Mr Brendon Roberts
Team Leader
Key Sites Assessments
Department of Planning and Environment
GPO Box 39
Sydney NSW 2001

**New South Wales Rugby League Centre of Excellence
Site 18 – Sydney Olympic Park (SSD 7745) – Notice of Exhibition**

Thank you for your letter dated 24 October 2016, requesting Transport for NSW (TfNSW) review and comment on the above.

Figure 1: Car park layout (Source: Applicant's architectural plans)

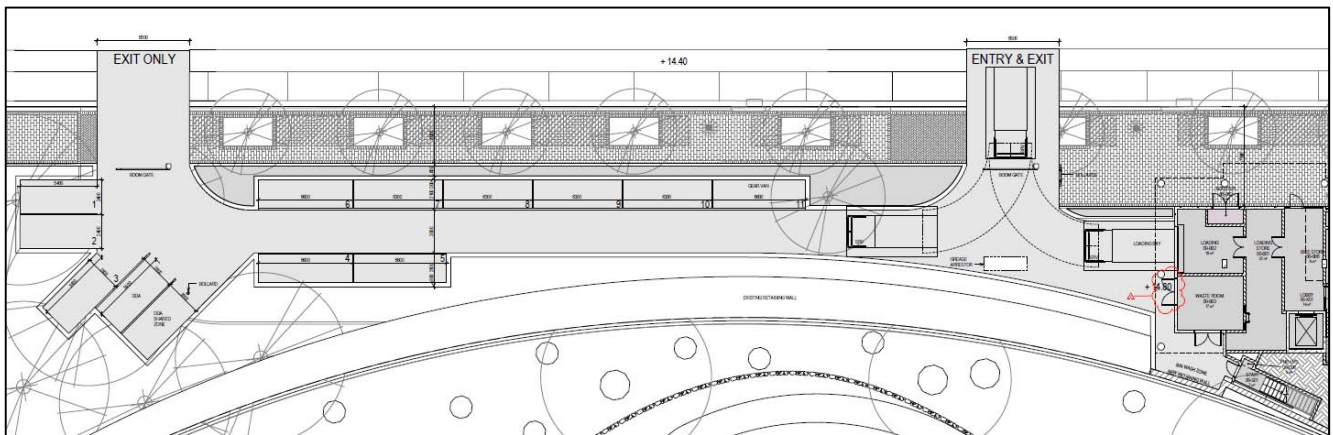
Based on the Figure 5.1 of the Traffic Report, two driveways are proposed for the site on Dawn Fraser Avenue with one driveway for two way movements and the other driveway for egress movements only. From pedestrians and cyclists safety perspective, TfNSW requests that the applicant provides one driveway for ingress movements only and the other driveway for egress movements only. This arrangement would also have the potential to minimise the impacts on the existing bus services which operate via Dawn Fraser Avenue.
